**Town and Country Planning Act 1990  
Application for Permission to Develop Land**

**Response from Pollution & Noise Control**

<b>PNC Reference No:</b>	WK/201723142
<b>Name of Planning Officer dealing with the matter:</b>	Farzana Tabasum
<b>Application Number:</b>	2016/92298
<b>Proposed Development:</b>	Outline application for re-development of former waste water treatment works following demolition of existing structures to provide employment uses (use classes B1(c), B2 and B8)
<b>Location:</b>	North Bierley Sewage Treatment Works, Bradford Road, Oakenshaw, Bradford
<b>Date Required By Planning:</b>	16/11/2017

ILLUSTRATIVE MASTER PLAN

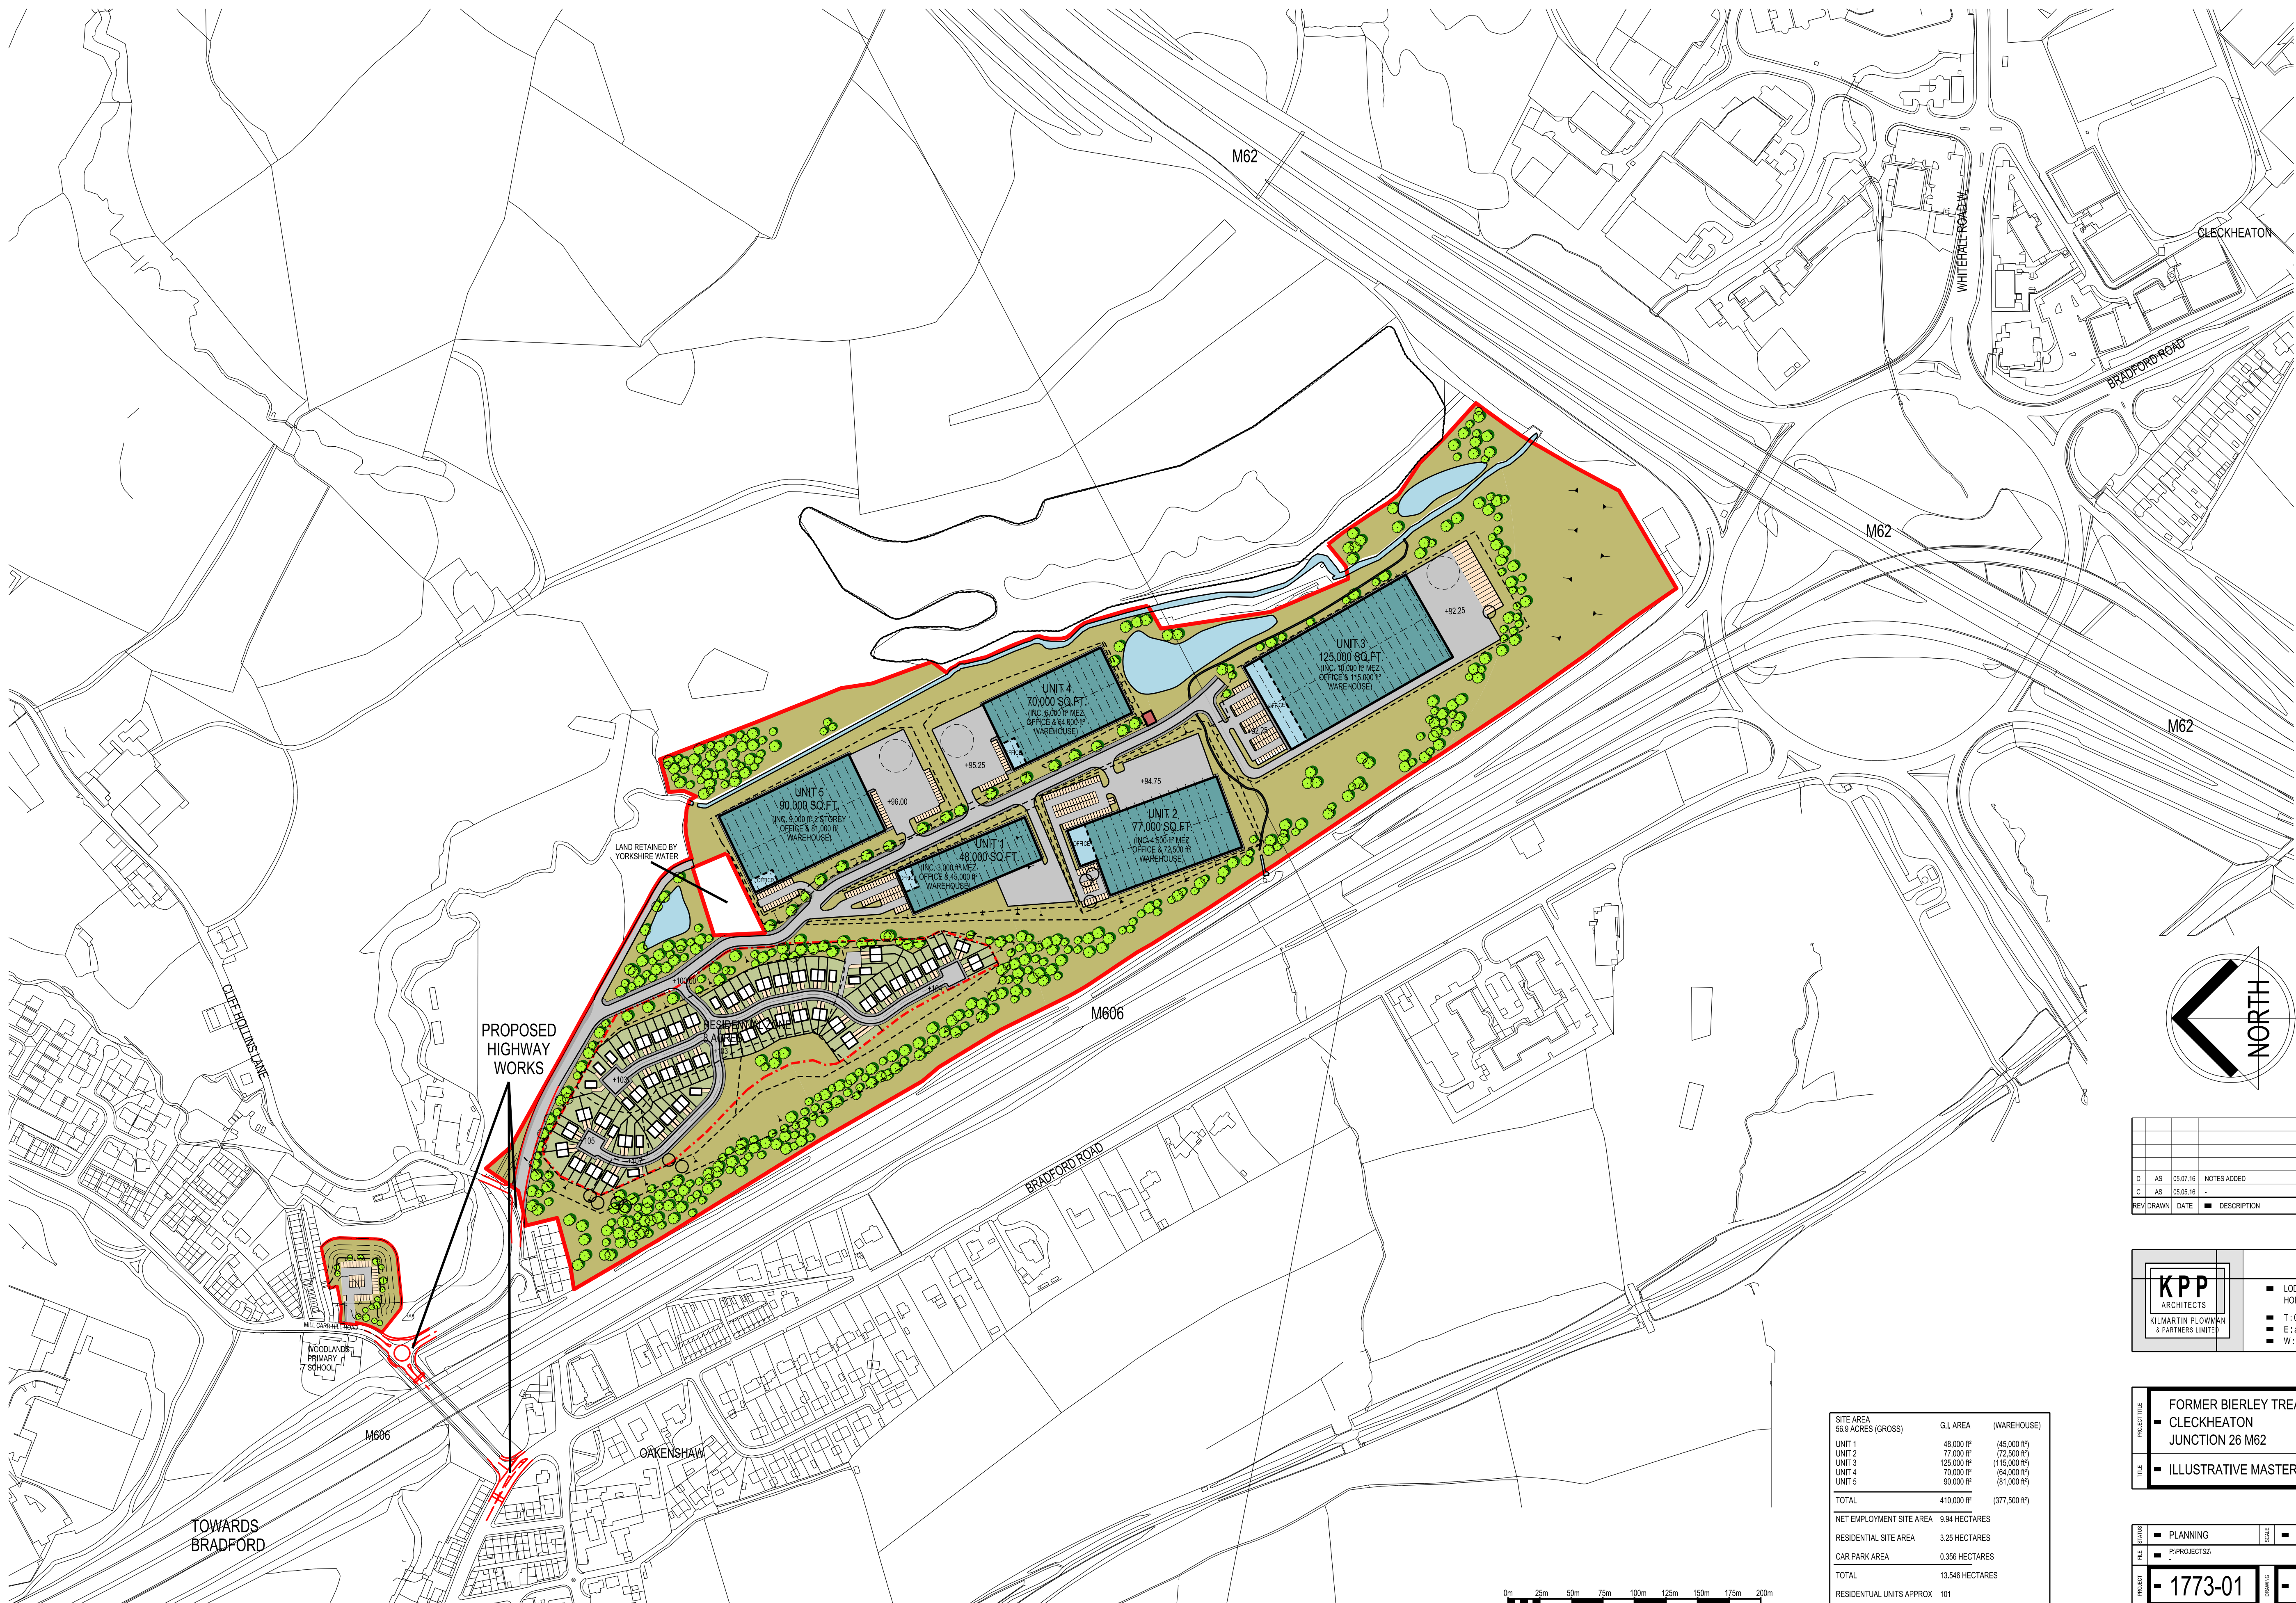
I understand that the site layout has yet to be finalised. There is an opportunity to use the commercial unit closest to the existing residential properties at Cliff Hollins Lane as an acoustic barrier for the remainder of the site. We would therefore expect that this is considered when deciding the final layout together with ensuring that this unit is allocated to a less noisy use and that potentially noisy activities at this unit (such as service yard area and external plant) are orientated so that they are at the far side of the unit away from the residential properties.
